Technical Note

Project No: ITB14224
Project Title: Nursery Fields
Title: Response to WSCC Consultation Comments
Ref: ITB14224-021 TN
Date: 1 July 2021

- 1.1 Landform Bersted Ltd (Landform) has submitted a planning application to Arun District Council (ADC) for 225 new homes on land to the north of Chalcraft Lane known as Nursery Fields (planning ref: BE/87/21).
- 1.2 West Sussex County Council (WSCC), in their capacity as the statutory consultee for matters relating to the operation and safety of the local highway network, has been consulted on the proposed development by ADC. A response to the consultation was submitted by WSCC on 22nd June 2021. As part of this response, WSCC has sought clarification on the Road Safety Audit.
- 1.3 This Technical Note has been prepared to bring together the information sought in respect of the Road Safety Audit and to take the opportunity to provide clarification on comments made by WSCC in respect of land reserved for a cross boundary vehicular link.

APPENDIX 3
LAND USE AND ACCESS PARAMETERS PLAN (REF:
01304_PP_01_P4)

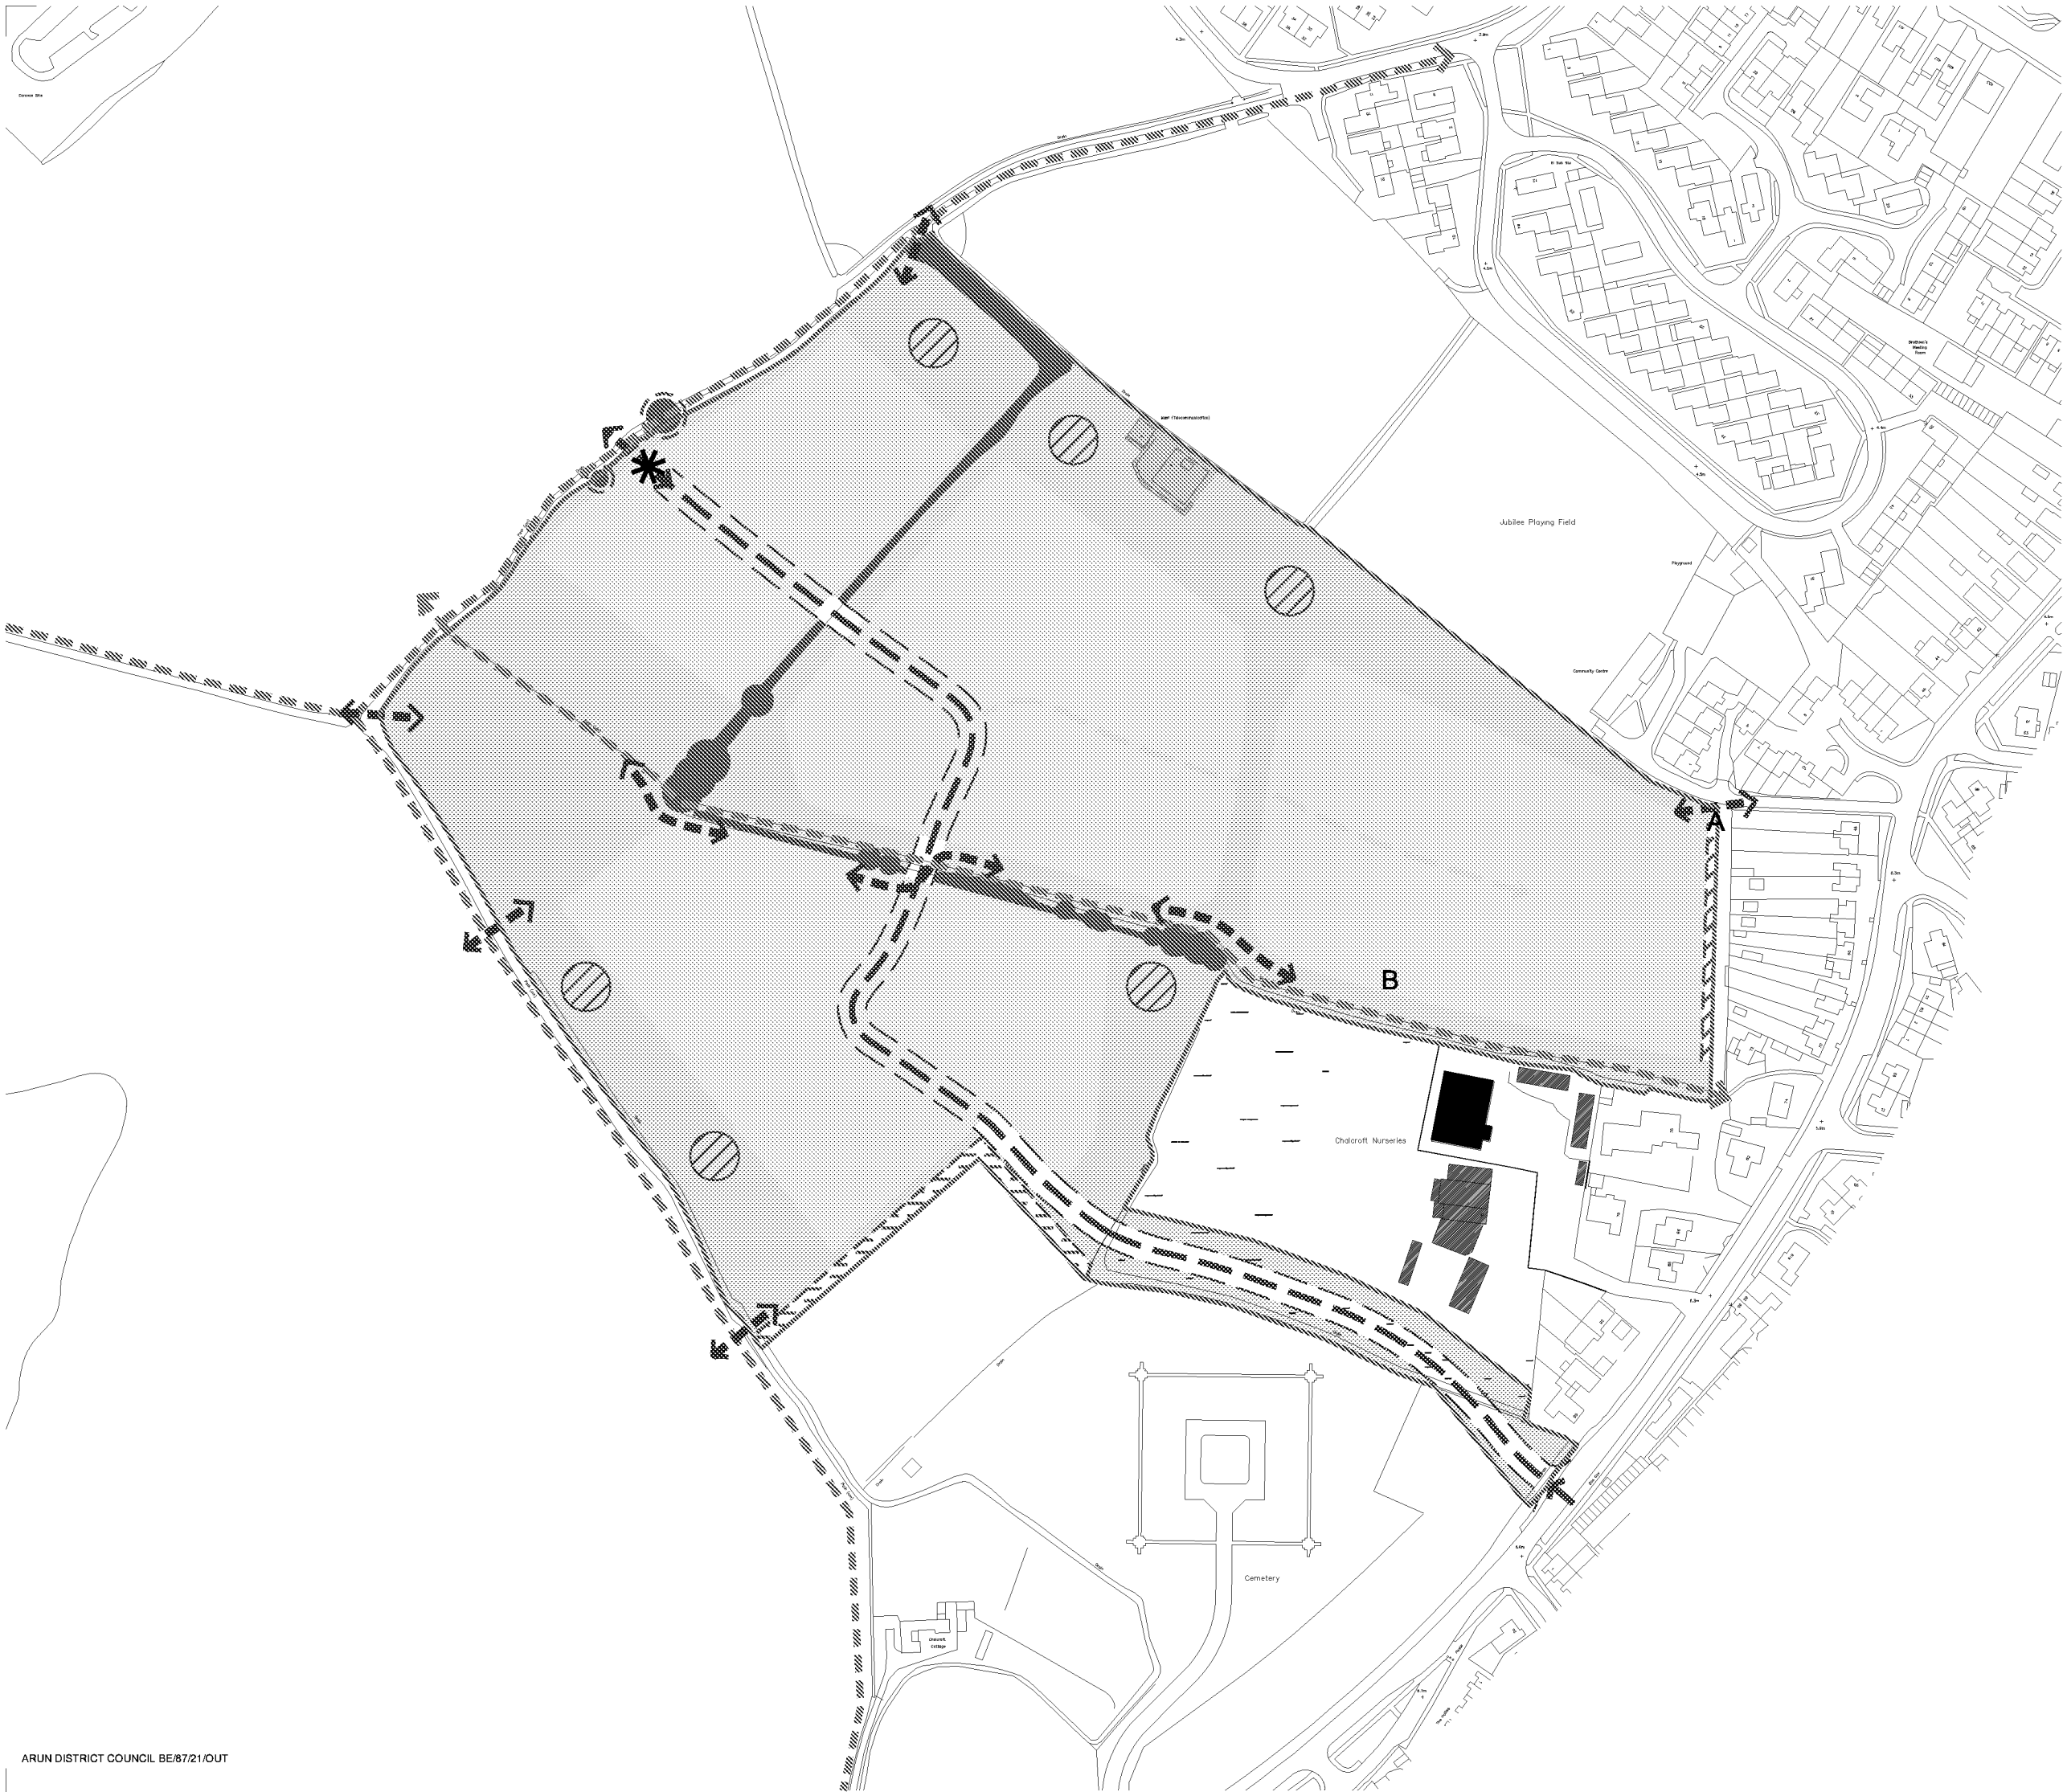
- 3.1 Paragraph 25 of the WSCC response dated 22nd June 2021 discusses cross boundary connections between the proposed development site and the wider West of Bersted SD3 allocation and notes that submitted parameter plan (ref: *Green Infrastructure Parameter Plan 01304_PP-02 Rev P2*) does not reflect that a potential vehicular link can be formed.
- 3.2 It should be noted that Parameter Plan 01304_PP-02 P2 identifies an area where land at the end of the primary route through the site is to be safeguarded in order to provide flexibility for a potential cross-boundary vehicular link to be formed. An extract of the Parameter Plan and the relevant inclusion within the key is provided at **Image 3.1**:

- 3.3 This area of land reserved for a potential link is also identified in Land Use and Access Parameter Plan 01304_PP-01 Rev P4, an extract of which is provided at **Image 3.2**:

- 3.4 Detail relating to the safeguarding of the land, including the extents and trigger mechanisms, are to be included and agreed as part of the Section 106 Agreement. It should be noted that any future development proposals that incorporate a cross boundary link would require planning permission, including an assessment of the traffic impacts associated with the formation of a cross boundary link. The safeguarding of the land does not imply that a link will be formed but provides flexibility to the adjacent landowner should this link be considered of benefit in bringing forward the wider SD3 site.

APPENDIX 5
SITE ACCESS PLAN (REF: ITB14244-GA-009B)

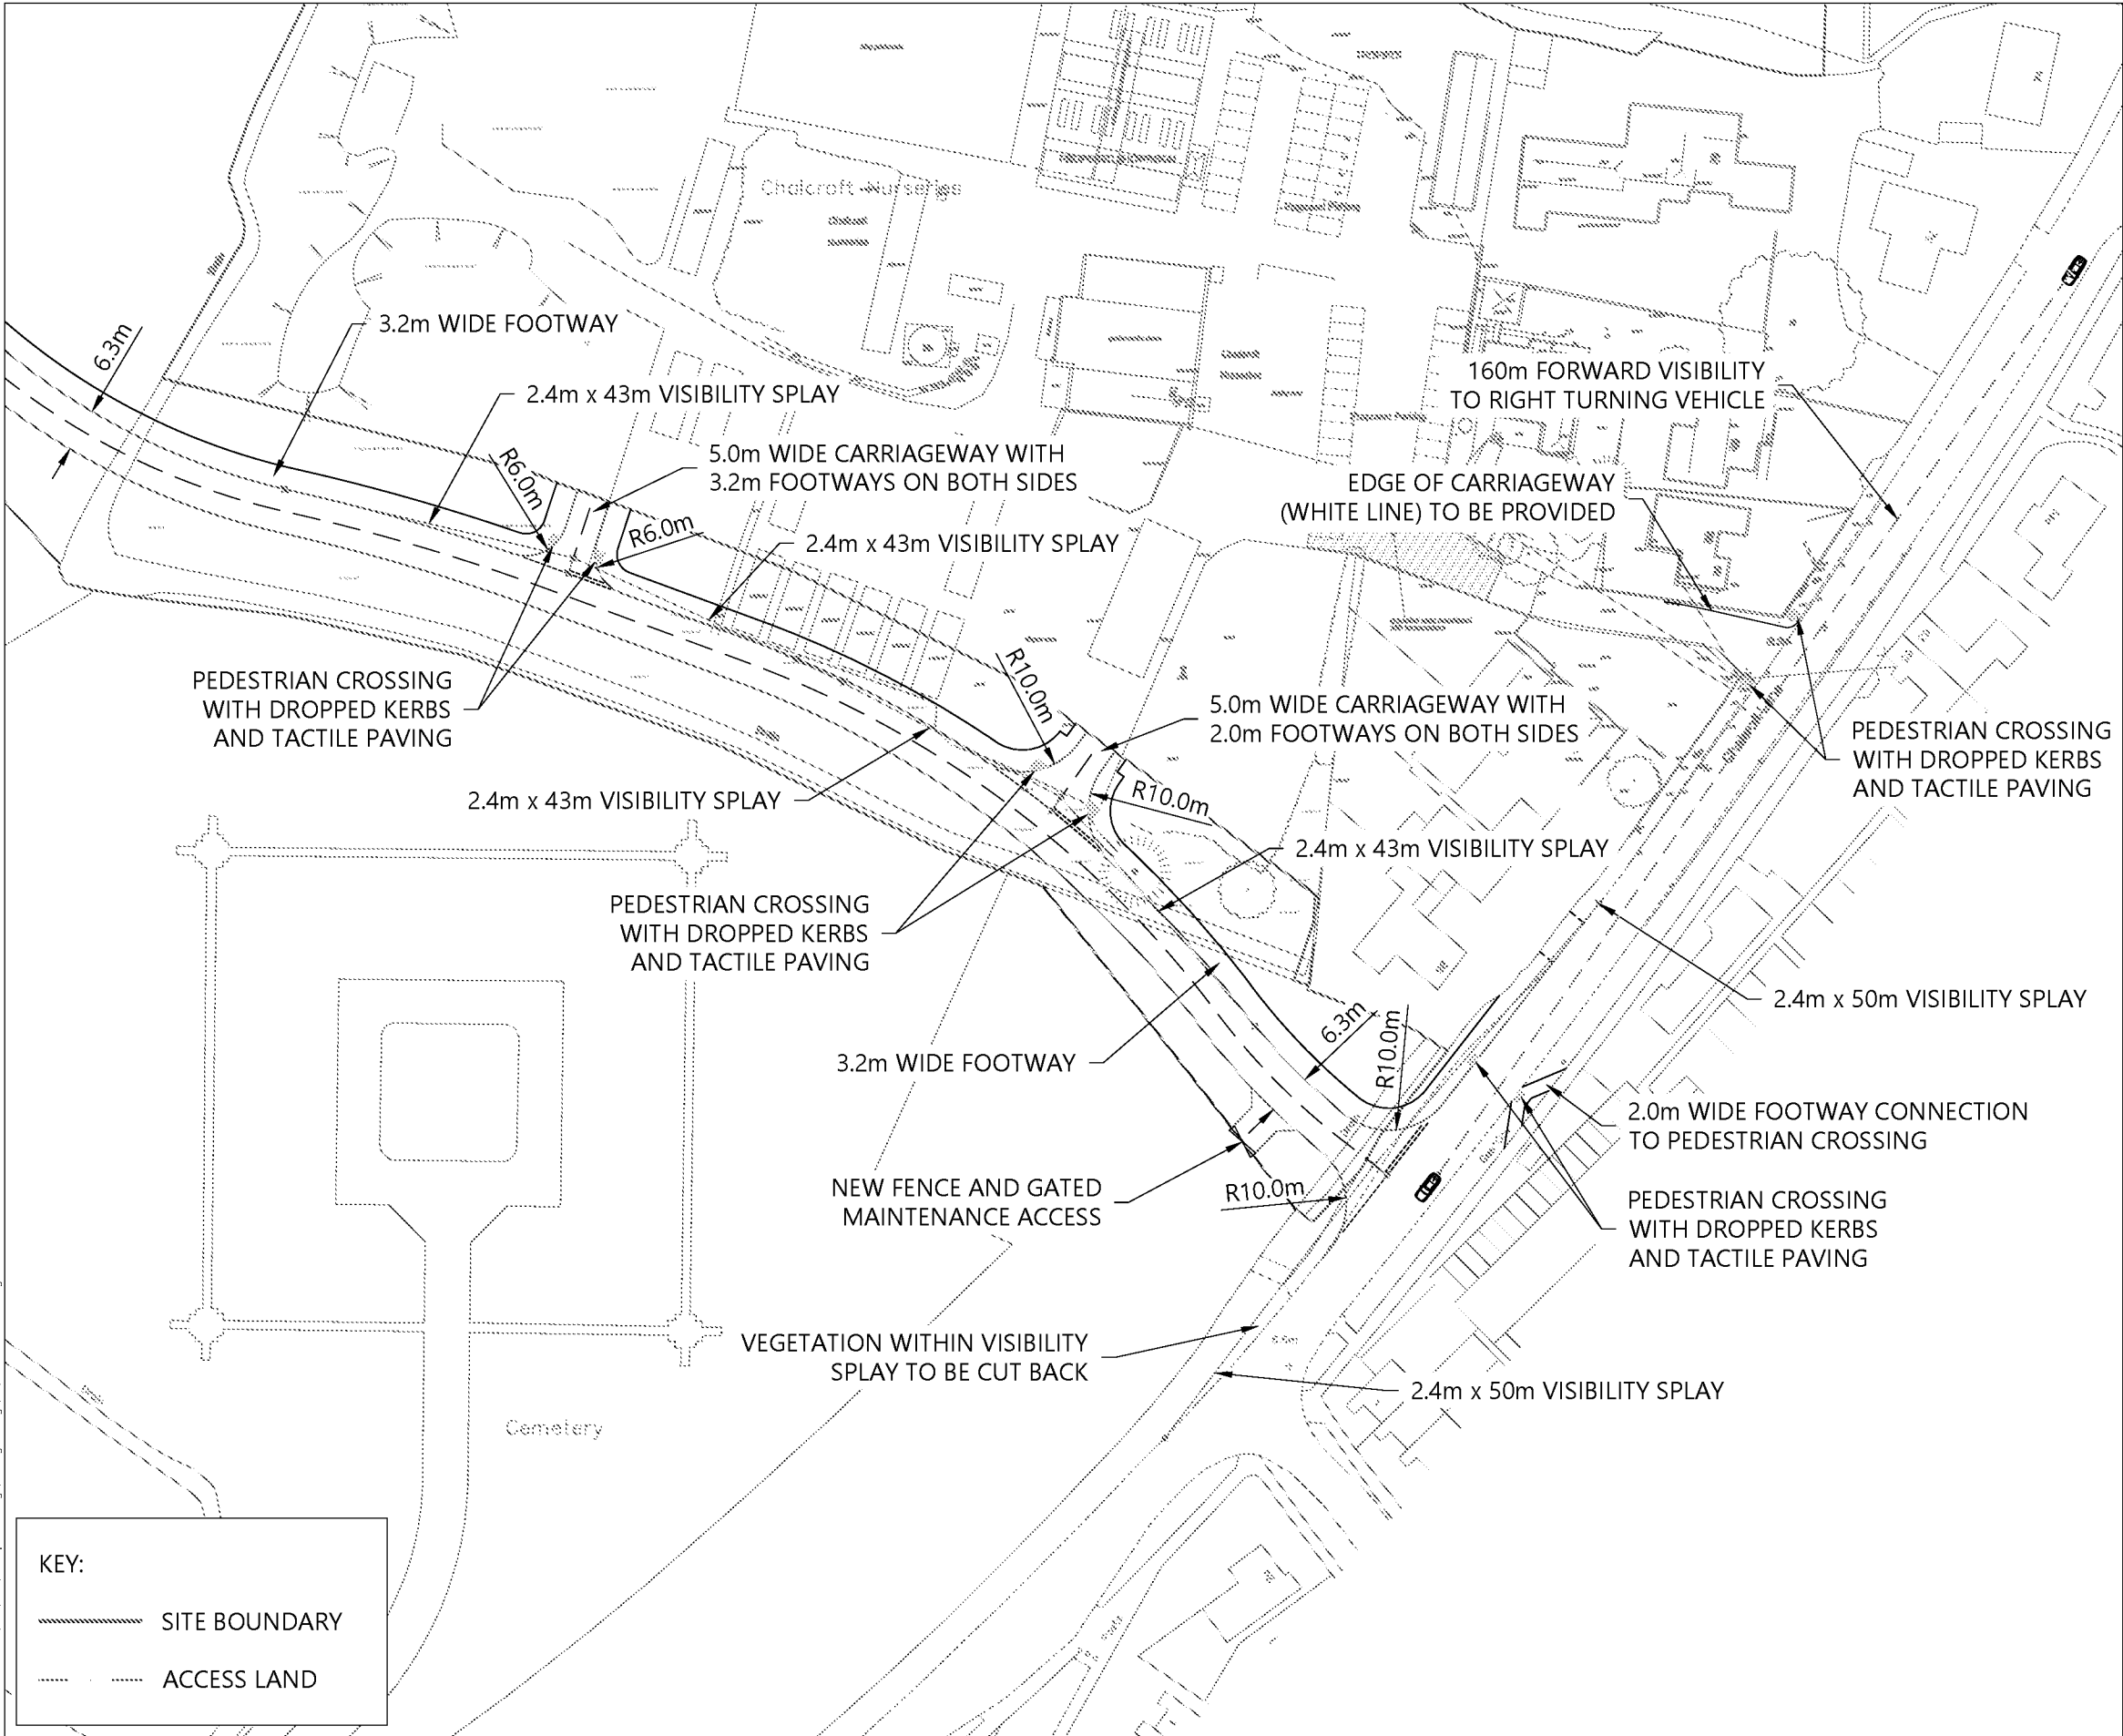
- 2.4 In response to the WSCC consultation response, written confirmation has been sought from the Auditor to confirm that they have had the opportunity to review drawing ITB14224-GA-009 Rev B and whether they have any further safety recommendations or comments. Correspondence from the Auditor dated 1st July 2021 identified the following matters:

- The provision of a level crossing over the bellmouth for the continuation of the pedestrian route along Chalcraft Lane – the Design Team confirms that dropped kerbs and tactile paving will be incorporated into the S278 detailed design.

- No transition is provided between the shared-use cycle route adjacent to the access road and the existing pedestrian footway – a shared-use cycle route is not including in Drawing ITB14224-GA-009 Rev B. At the request of the Overseeing Organisation, the shared-use element of the footway adjacent to the site access road was removed during consultation on planning application BE/148/20. As such, there is no transition between footway and cycleway included with the arrangement and any comments relating to this matter are no longer of relevance.
